# DEVIATION REQUEST AND DECISION FORM

Project Name : Eagleview Subdivision  
 Ordinance No.(s) : 5226000001, 5226000001  
 Description : N2NW4 EX WLY 620.0 FT SEC 26-12-65,S2NW4 EX WLY 620.0 FT SEC 26-12-65

# LSC Response to EPC PCD deviation 1 comments

Deviation Exhibit

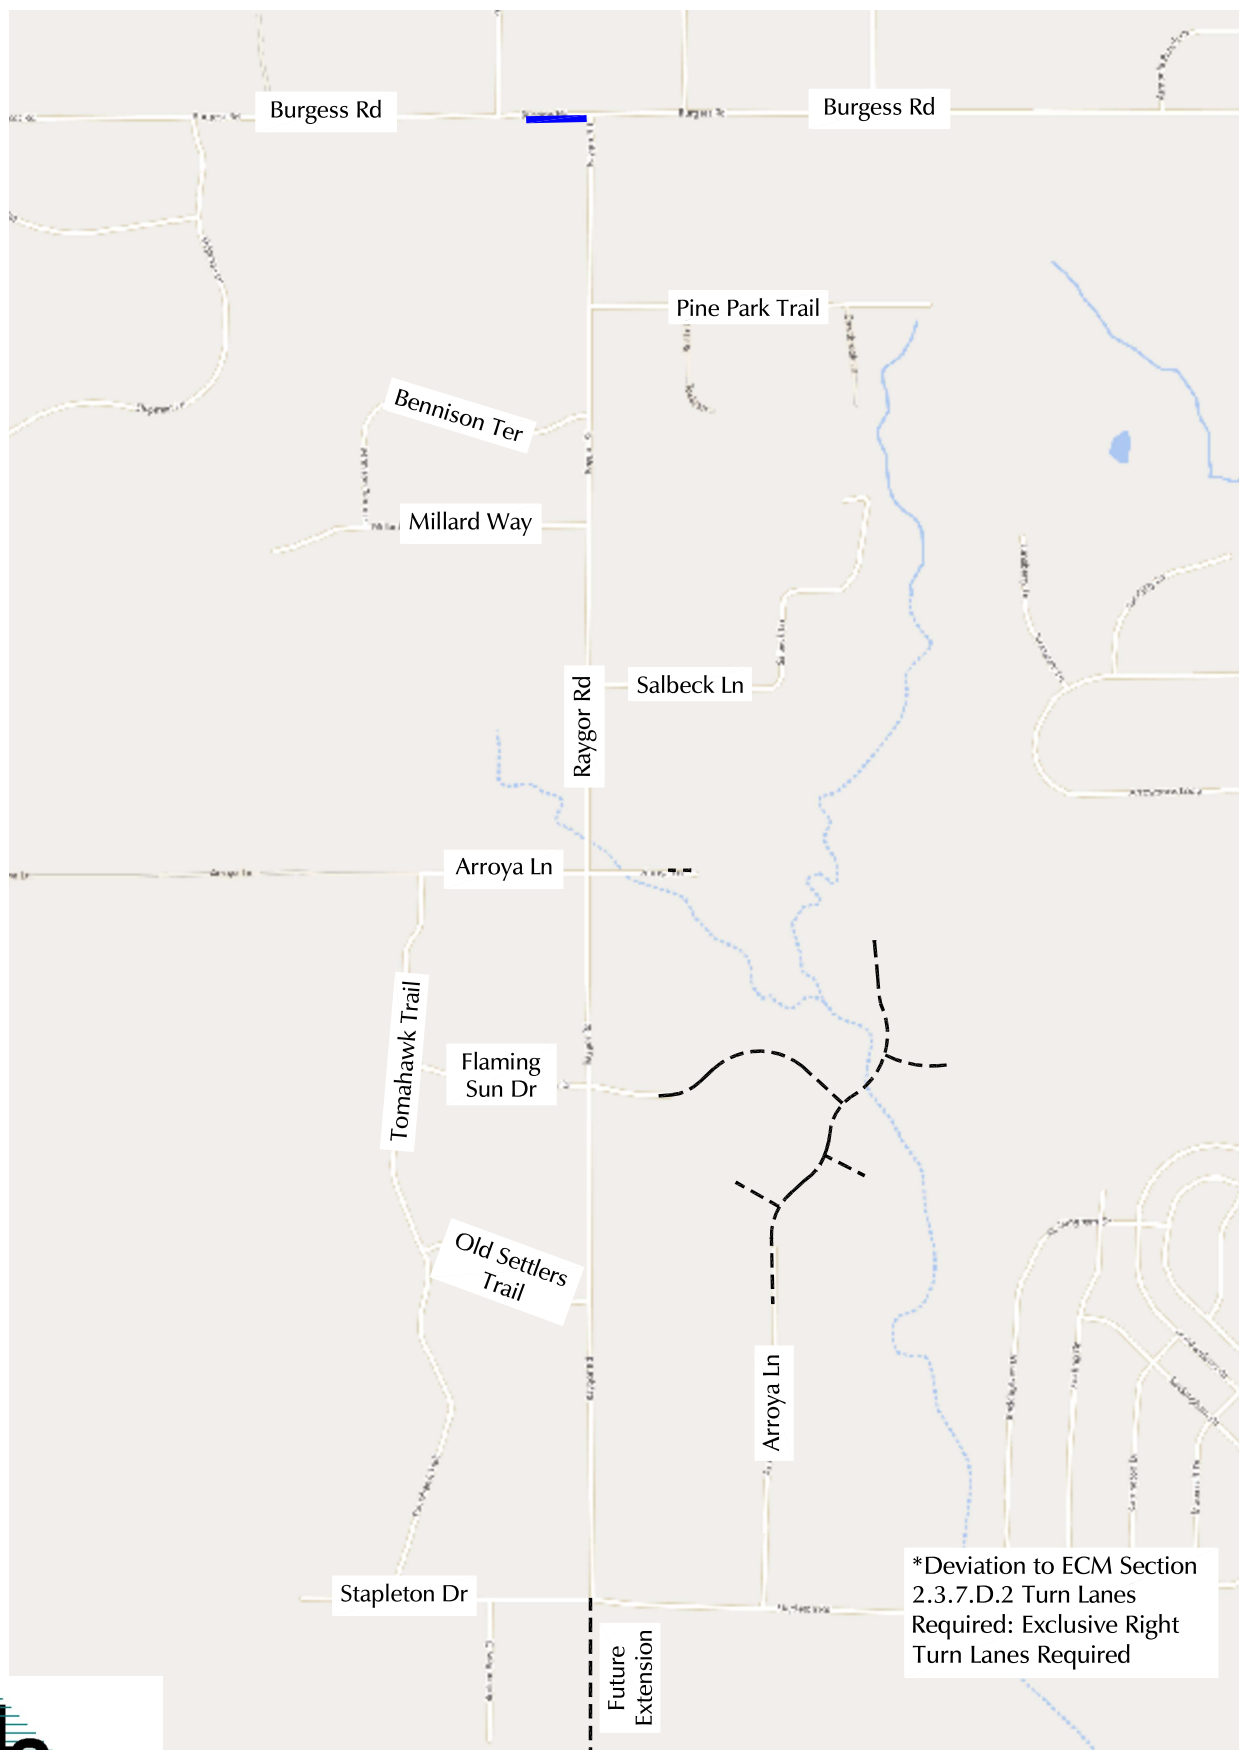
[Attach photos of the constraints described below](#)

[Explain future connections, timeline and impact/alternatives if not completed](#)

[A proposed alternative needs to accomplish the same design objective that the ECM requires. Unclear how the proposed alternative is equivalent to installing a right turn lane. The timeline for the future connection to the south is unknown so this interim condition may be in service for a long time. One proposed alternative that needs to be explored is shifting Burgess Rd to the north to accommodate the third lane. Another is to check CDOT criteria regarding the right turn lane. The current proposal is unlikely to be approved.](#)

Not sure how the striping proposed would reduce safety impact. Can this be quantified such as the highway safety manual computations for crash modifications/CRF?

**This Deviation is being withdrawn.**
